Planning Application Ref: AL/33/19/RES

Location: Barnside, Hook Lane, Aldingbourne, PO20 3TE

Description of works: Approval of reserved matters following the consent of AL/8/16/OUT (APP/C3810/W/16/3155330) for the erection of 14 No. dwellings with associated access, parking, landscape & open space

Mark Warwick
Tree Officer / Parks and Greenspace Team

DWG | Proposed Site Plan

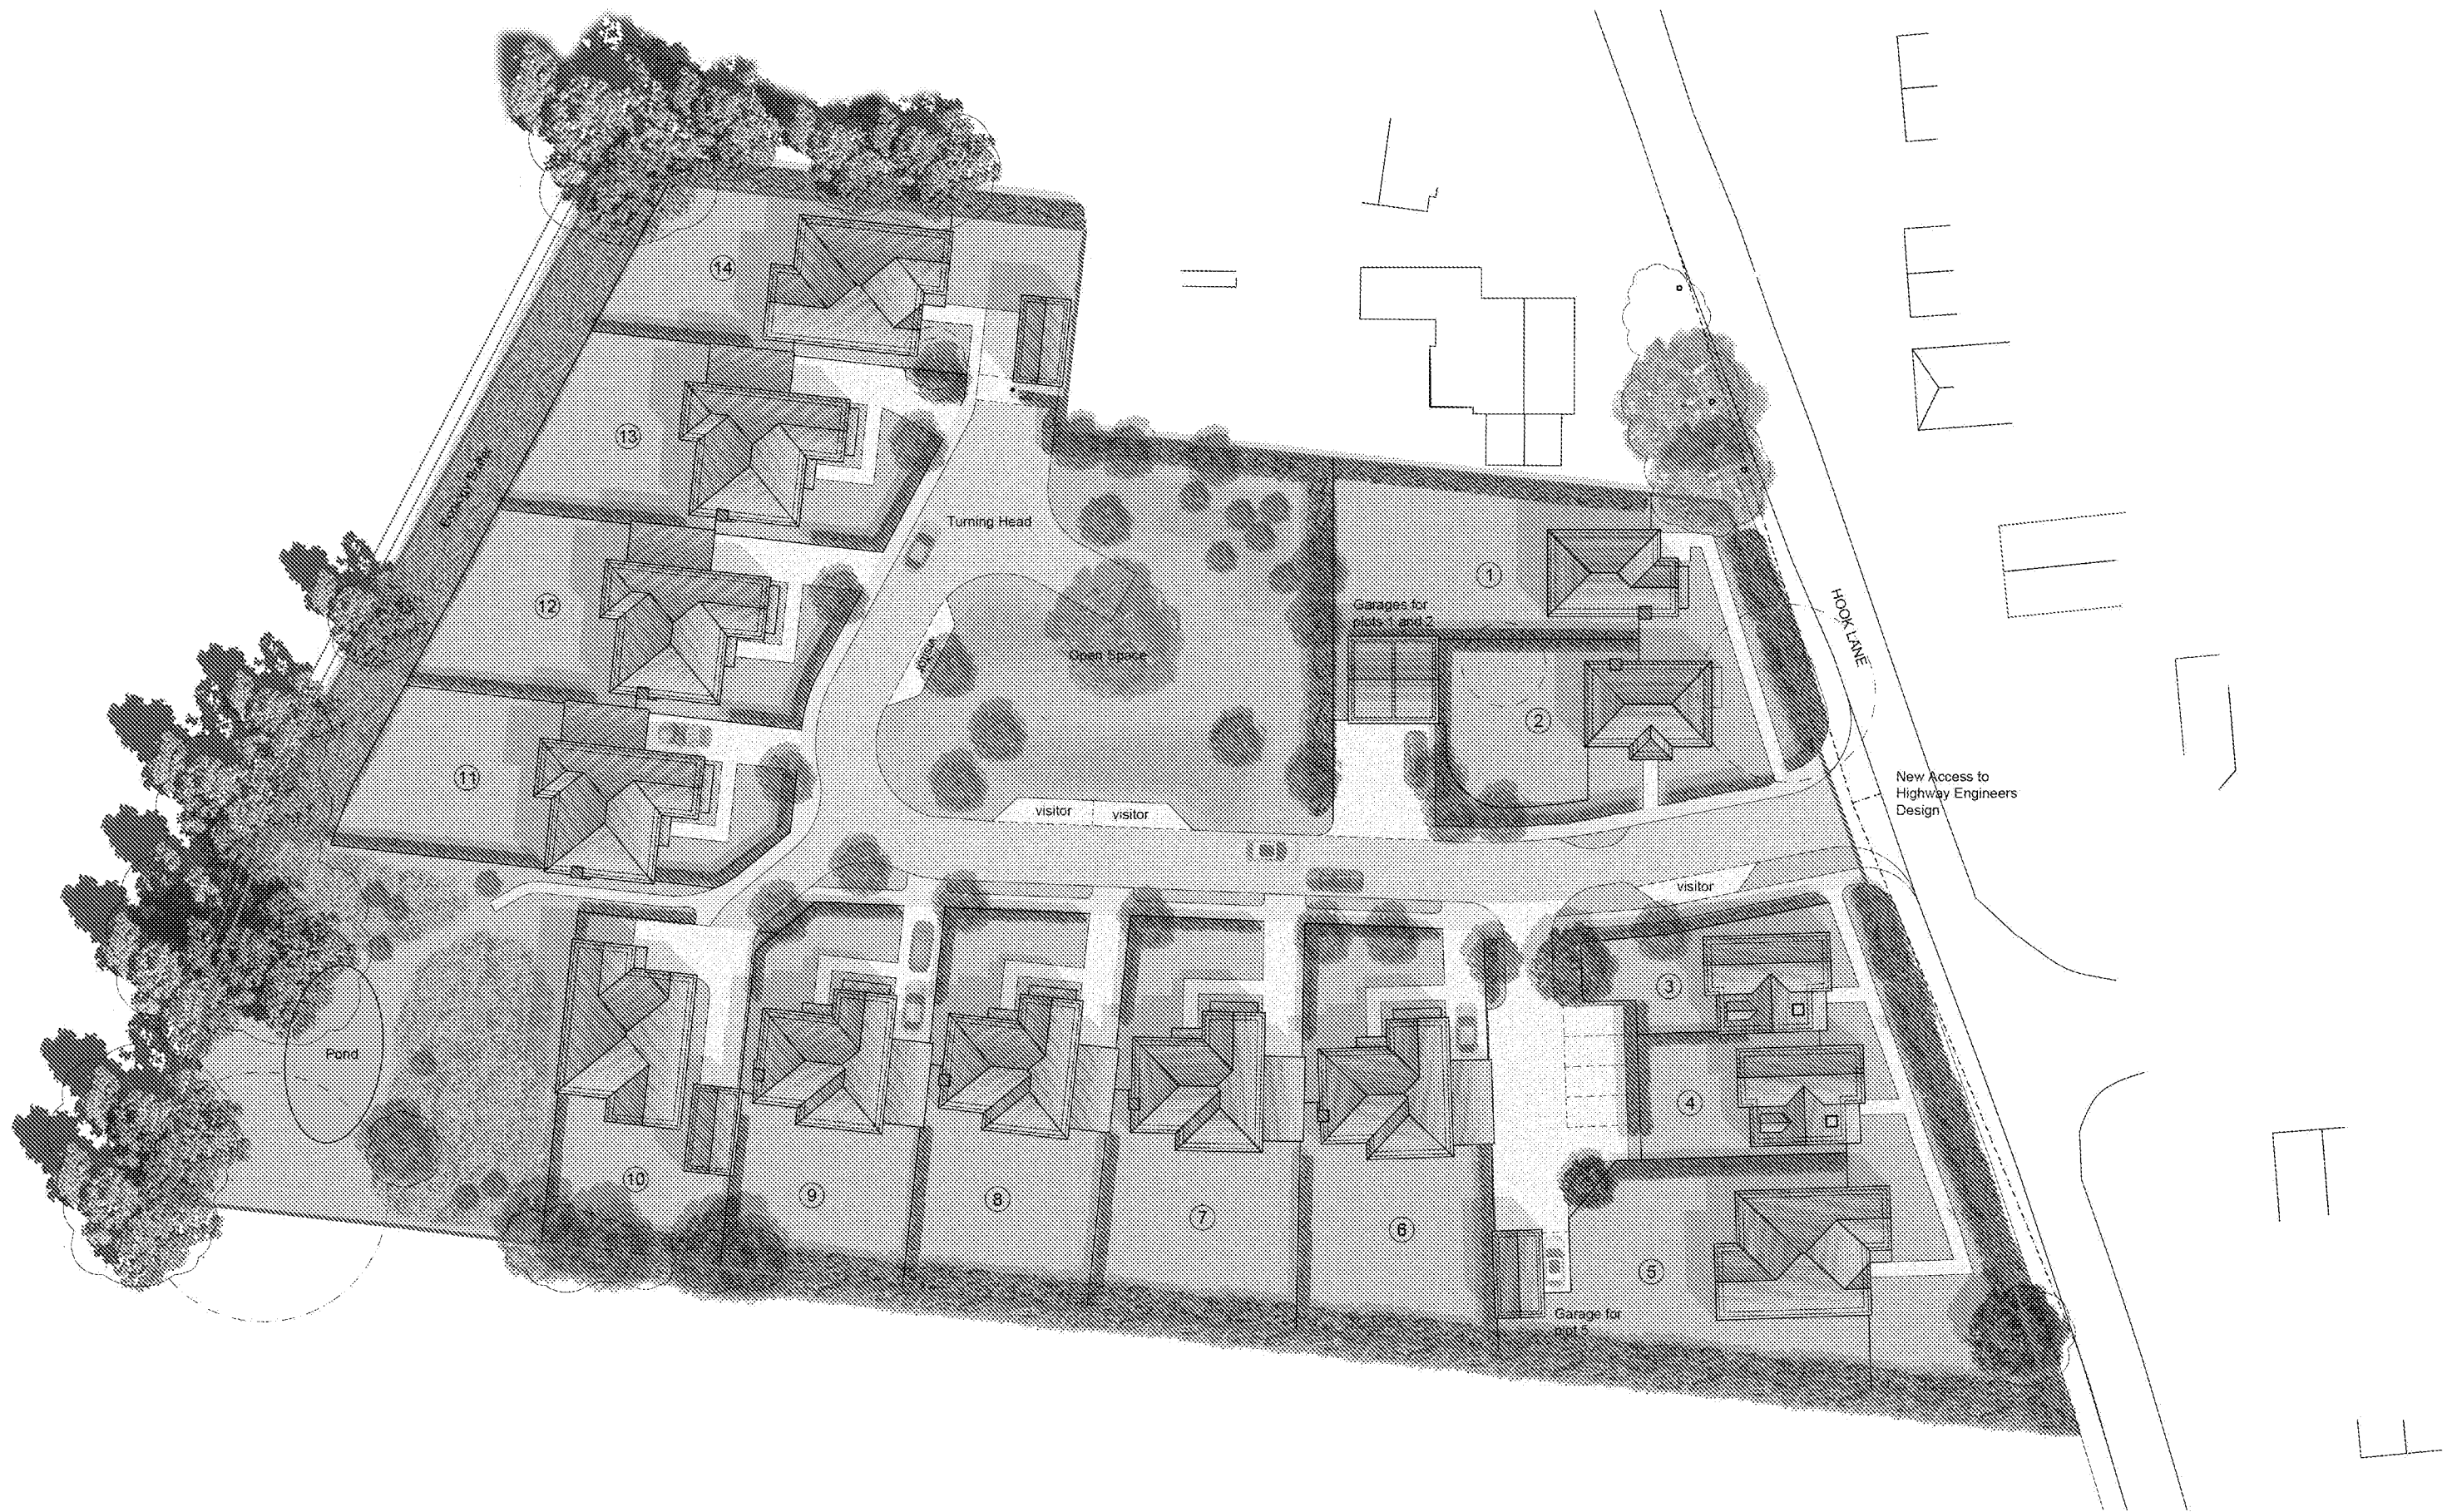
- Oak – T2 is proposed for removal, which I find unnecessary and unacceptable, especially as there appear to be alternative options for access onto the site. With imagination, it should be possible to re-locate the access to the south and re-configure the plot size/layout without any significant loss of unit numbers.

- I would like to see the applicant submit a revised layout, which accommodates (and allows for the long-term retention of) Oak – T2 and consequently positions any footway and/or carriageway construction wholly outside of its nominal root protection area (RPA). Should we receive a subsequent layout that I can support, it will be a simple case of applying my standard set of conditions to tie the applicant in to their own AIA, AMS and Tree Protection Plan – albeit revised to reflect those changes.

- As it stands, I must register an **OBJECTION** on the grounds of an unnecessary and unjustified proposal to remove Oak – T2. That said, I expect this sole arboricultural constraint to be easily overcome with a more sympathetic and revised layout.
